## Hearing Action Points

Application by Highways England for an Order Granting Development Consent for the A1 Birtley to Coal House Improvement Scheme

The following are the agreed actions arising from the **Issue Specific Hearing** (ISH1) on the draft Development Consent Order (DCO) held at the European Suite, Newcastle Gateshead Marriott Hotel, MetroCentre, Gateshead, Tyne and Wear NE11 9XF on **Tuesday, 21 January 2020**.

Drawing Title: Figure 1 Site Compound Plan Detailed View, Junction 67

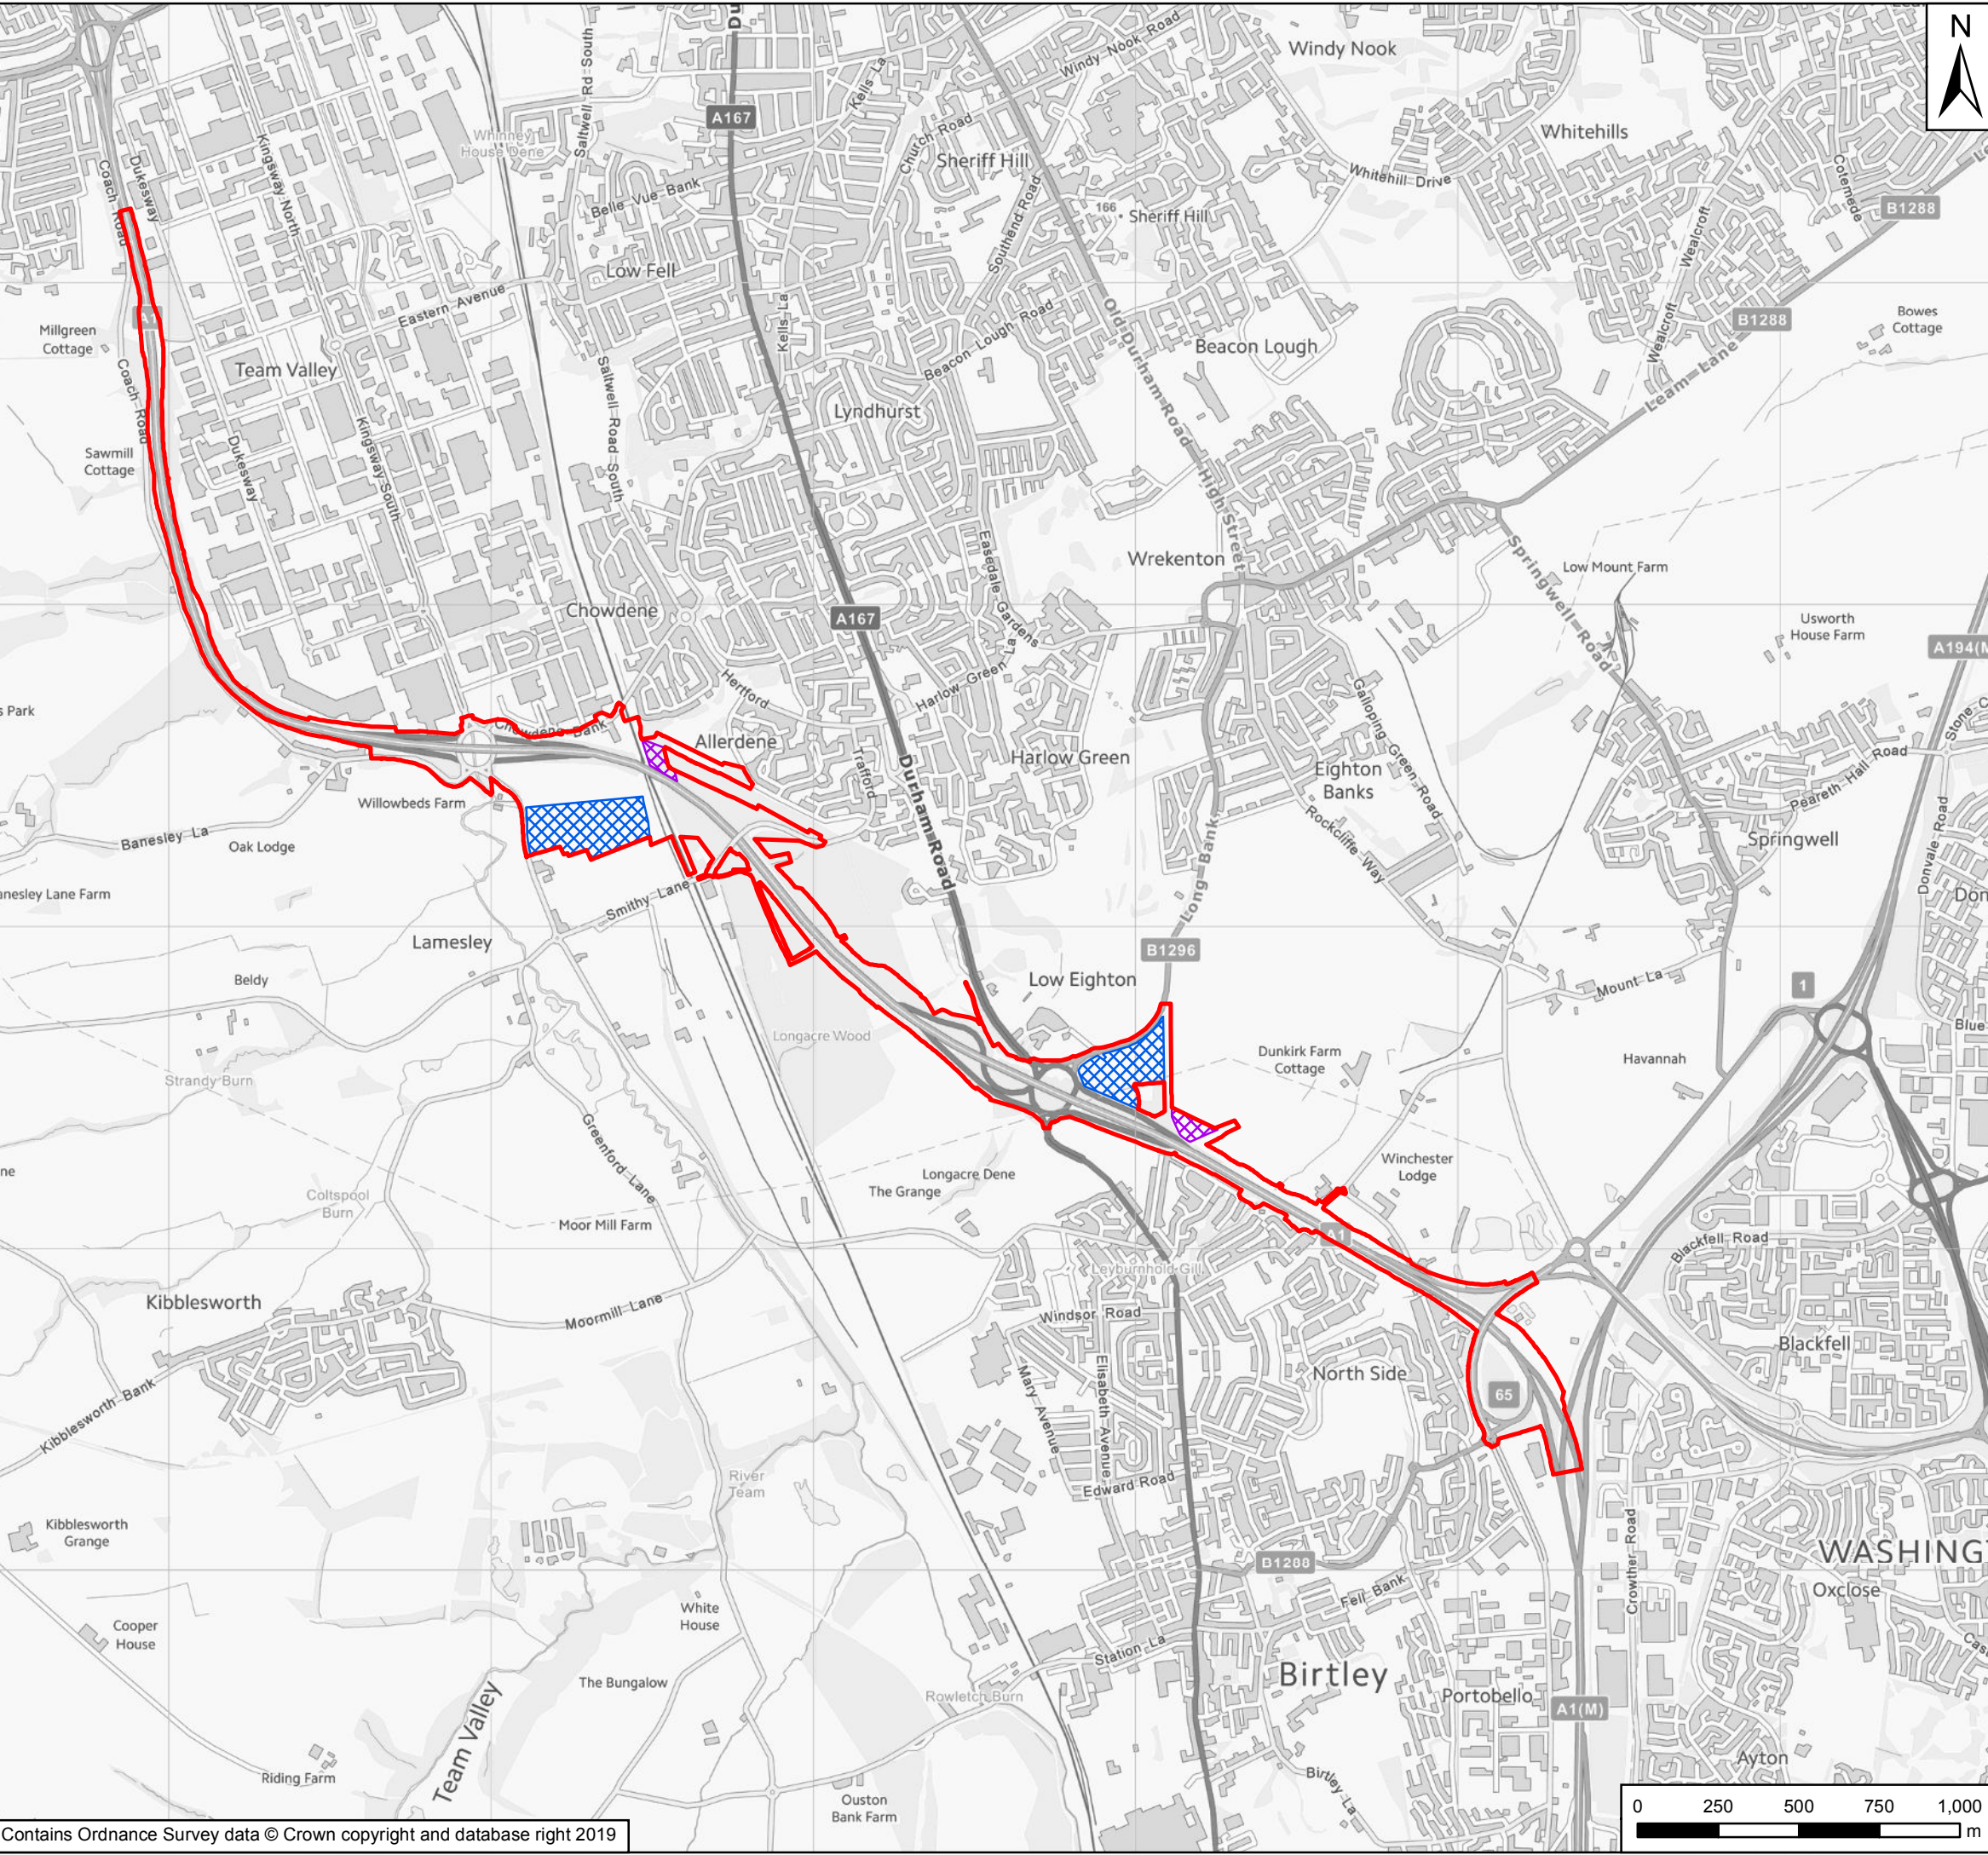
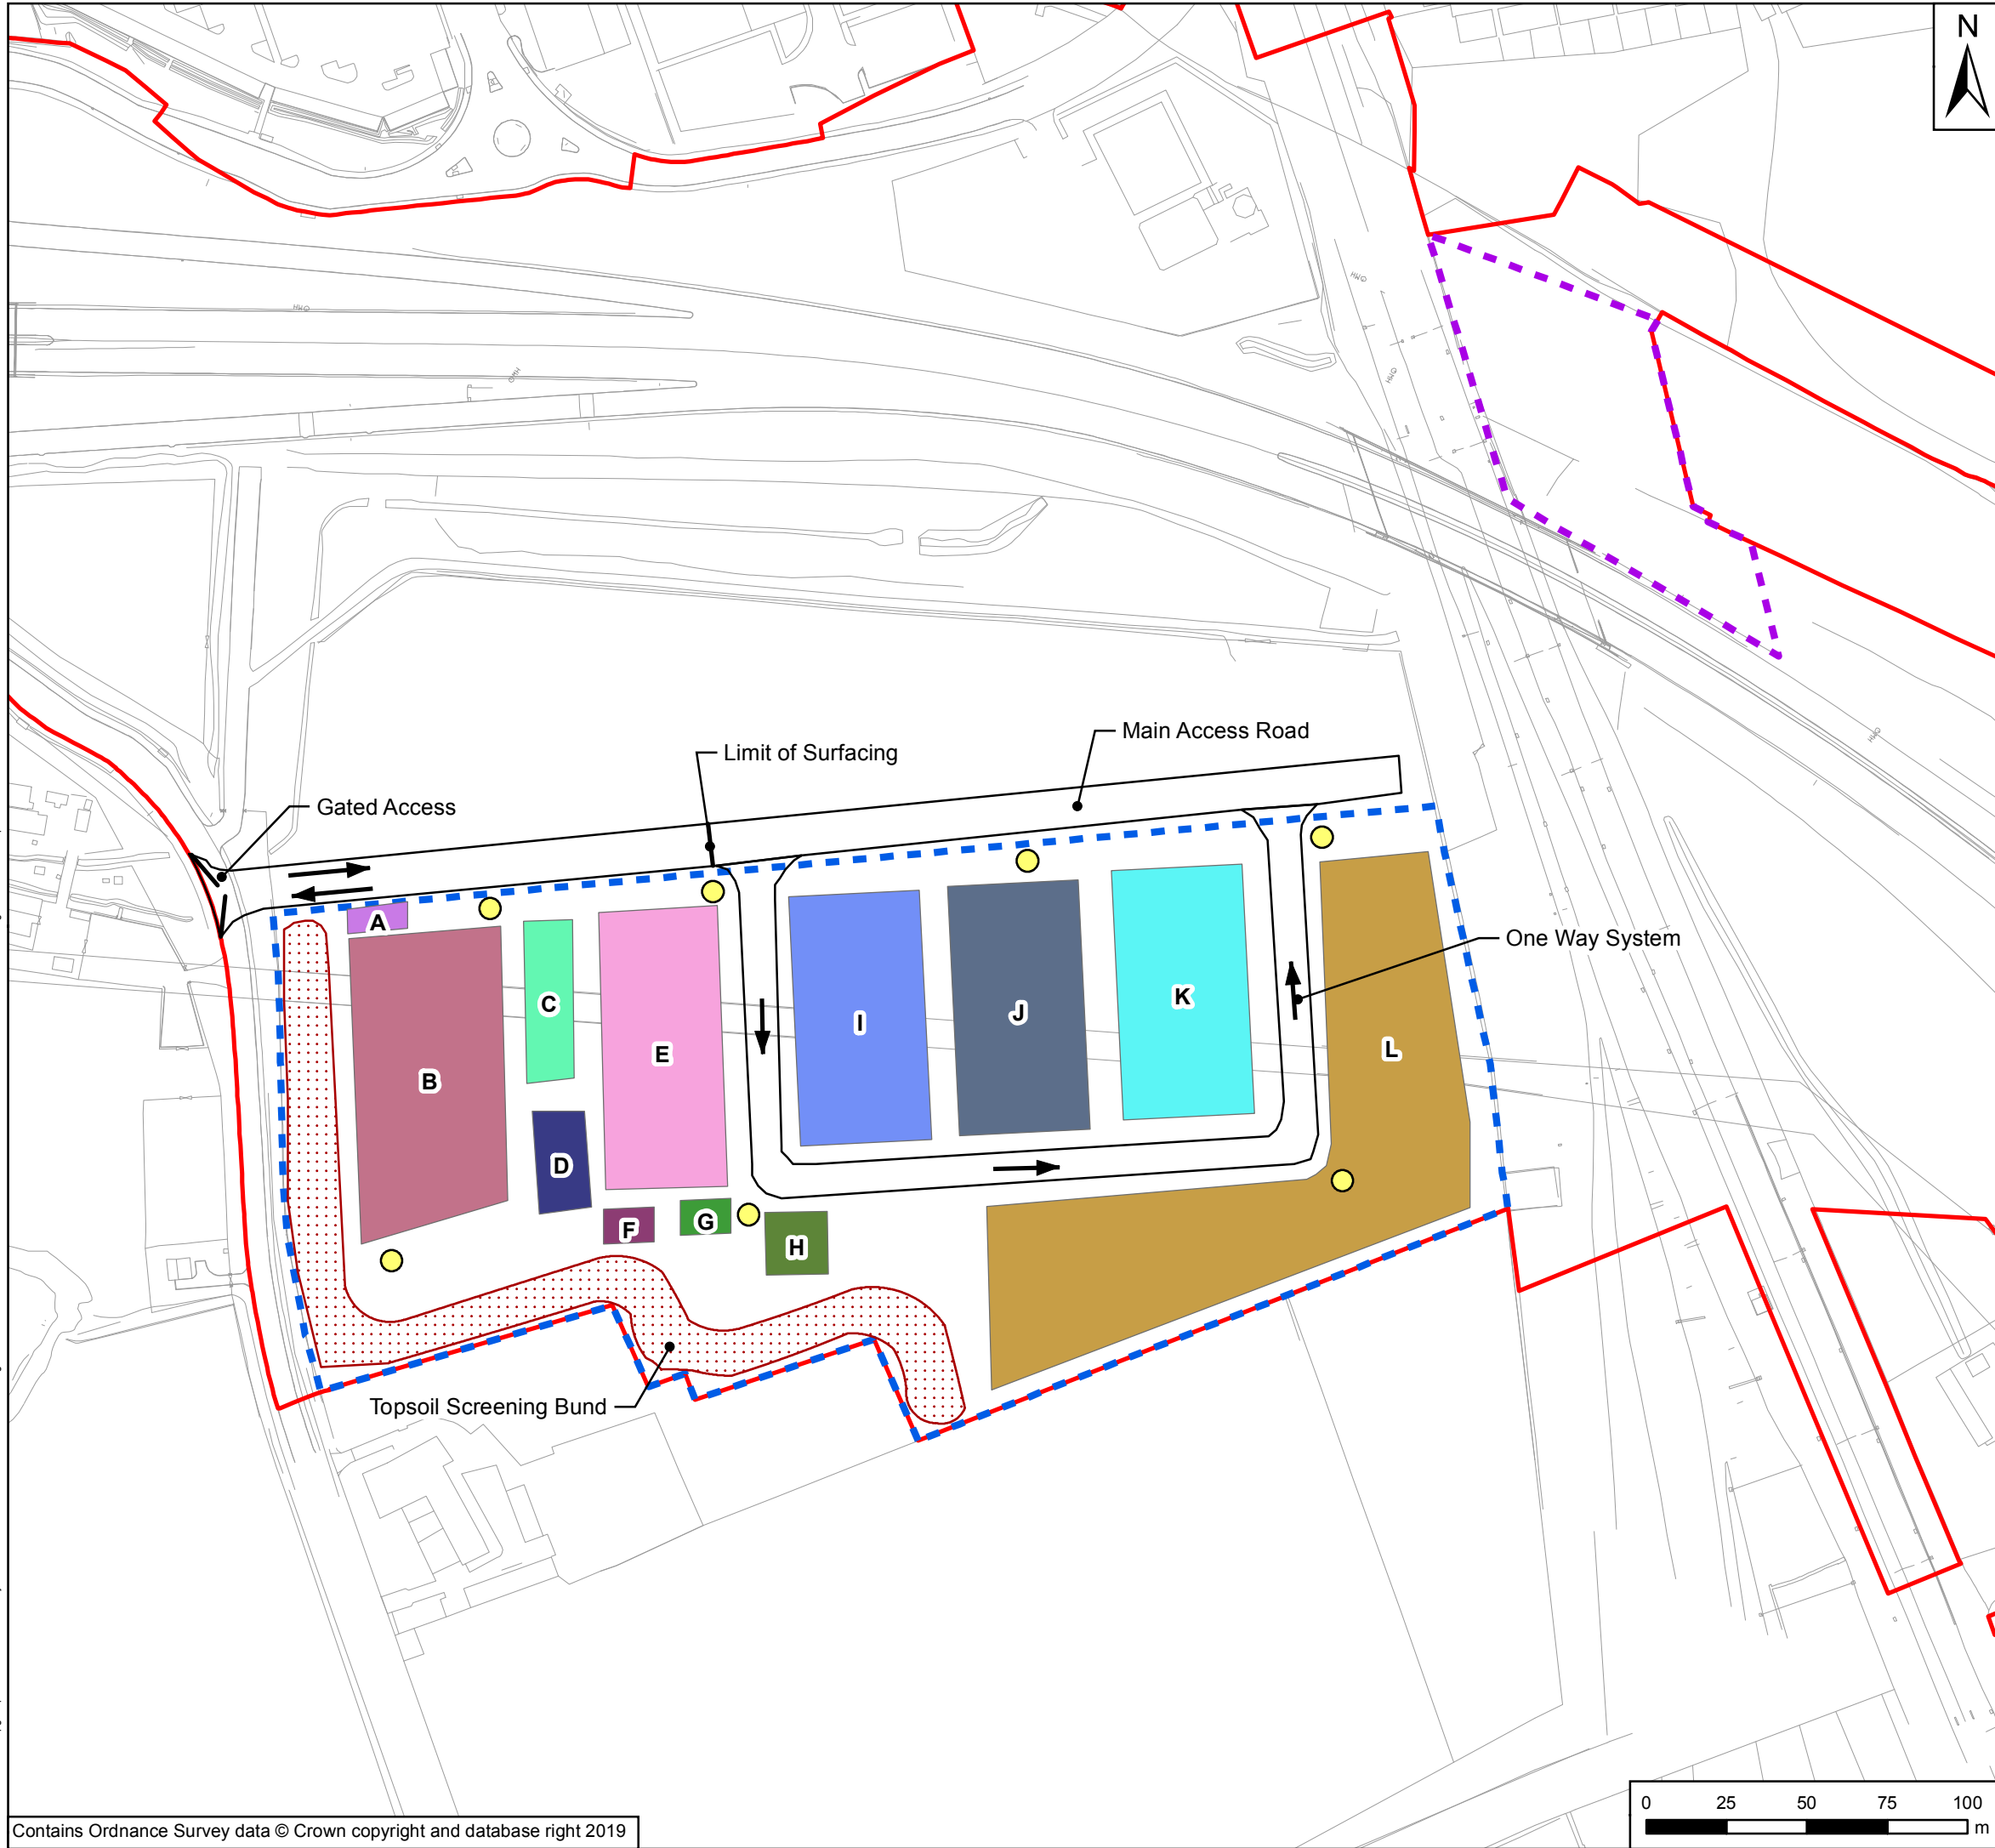
9	Schedule 1, ...further development a) – Provide an update on progress of discussions between Northern Gas Networks and the Applicant in relation to the detail of the layout within the construction compound adjacent to J67. Consider if further clarification is needed, either within the dDCO or the CEMP.	Applicant and Northern Gas Networks	D2
10	Article 37 – Consider implications of the removal of hedgerows and include details of the Council's position in the Statement of Common Ground (SoCG)	Gateshead Council	D2
11	Schedule 9 – Confirm that TPO No.21 is the correct reference and submit a copy of the TPO for the Examination	Gateshead Council / Applicant	D1
12	Schedule 1 – Provide justification for the necessity of each of the 'in connection with' works (a to v)	Applicant	D2
13	Explanatory Memorandum, Schedule 1 Authorised Development – add missing words ' <i>and associated development</i> ' to the first paragraph	Applicant	D2
